# CITY OF ALBUQUERQUE

**Re: MCT Industries Paint Booth Replacement, Grading and Drainage Plan,  
Engineer's Stamp Dated 11-07-2011 (D17/D047)**

Based upon the information provided in your submittal dated 11-08-2011, the above referenced plan can not be approved for Building Permit until the following comments are addressed:

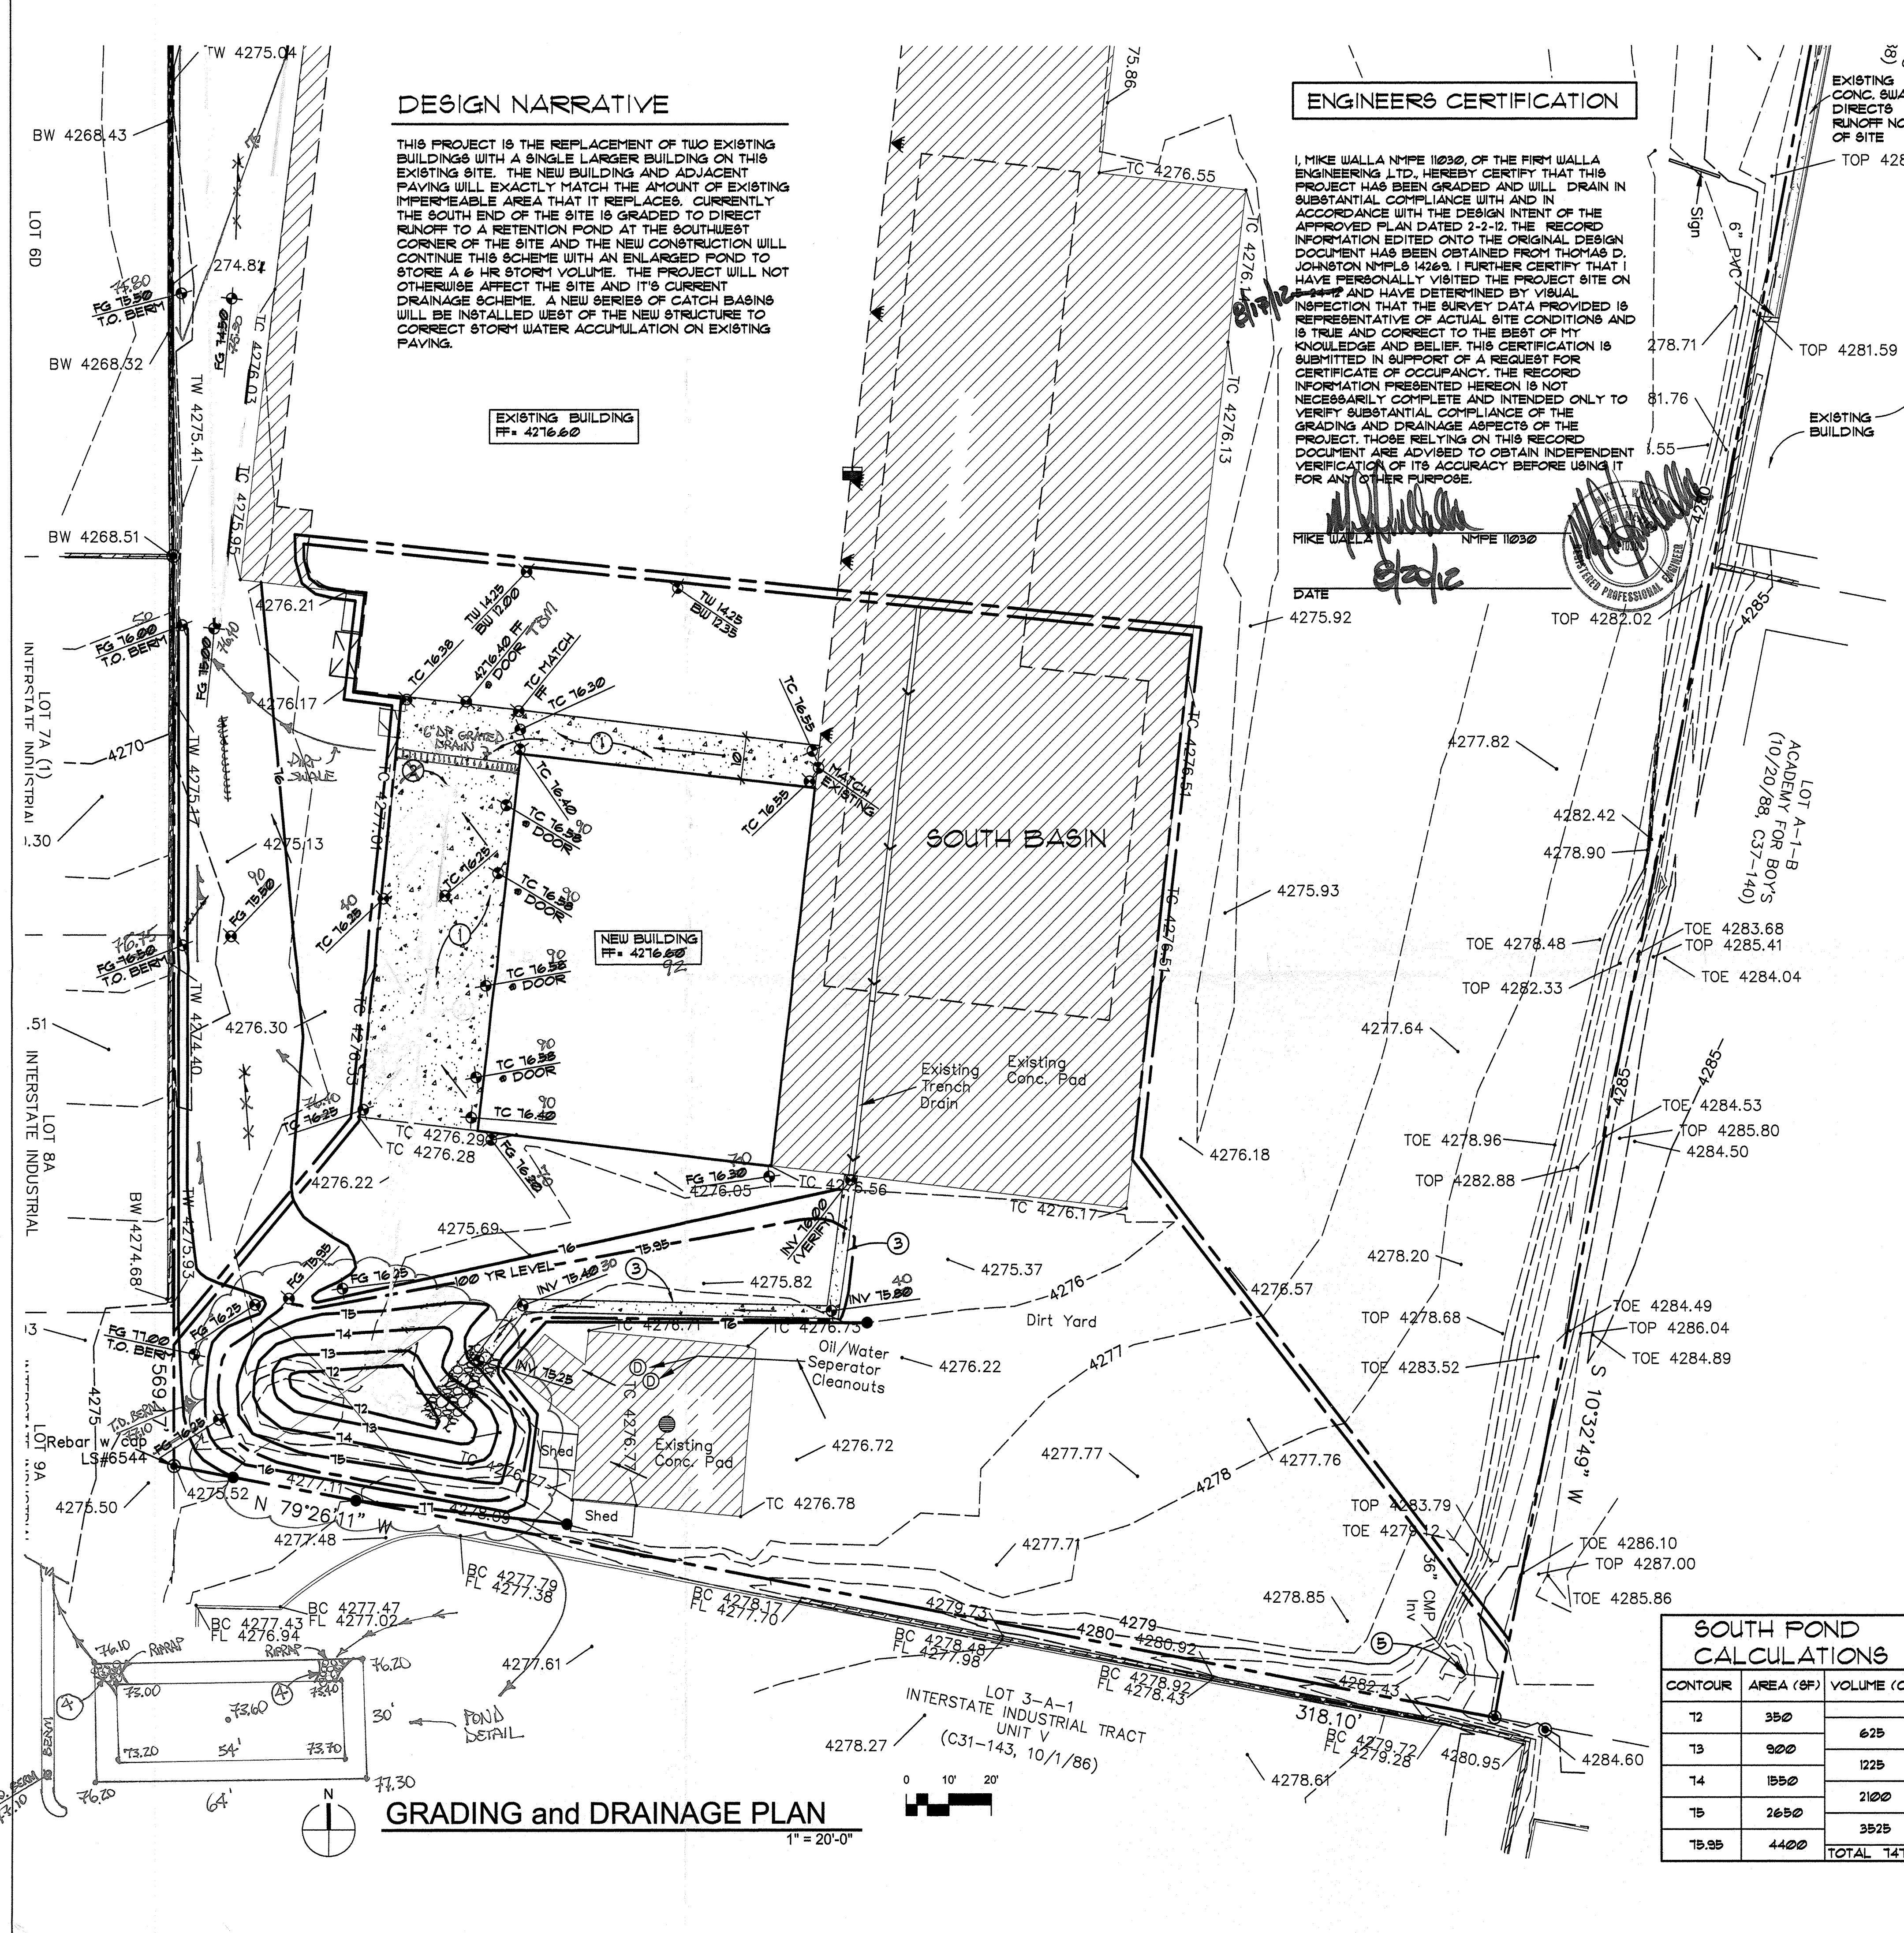
- Include all the offsite runoffs and explain how it will impact this site.
- Provide proposed pond calculations. Show the 100-Yr WSEL. Provide emergency overflow and calculations.

- Are there any slope protection being proposed for the pond at the end of the valley gutter and the 8" pipe.
- The top of pond elevation is "FG 79.90" next to a proposed contour with an elevation of 76.00. Please correct this elevation.

- There is existing hatch area to the east of the retention pond. Please note on the plan what this area is and were to and how does it drain.
- Another hatch area is shown on the east side of the building. Please indicate what this hatch area is.

- There is an area just west of the new building where the runoff ponds against the existing wall. Will this area be regarded?
- Does the pond to the north have adequate volume for the existing developed runoff for the northerly portion of this site?
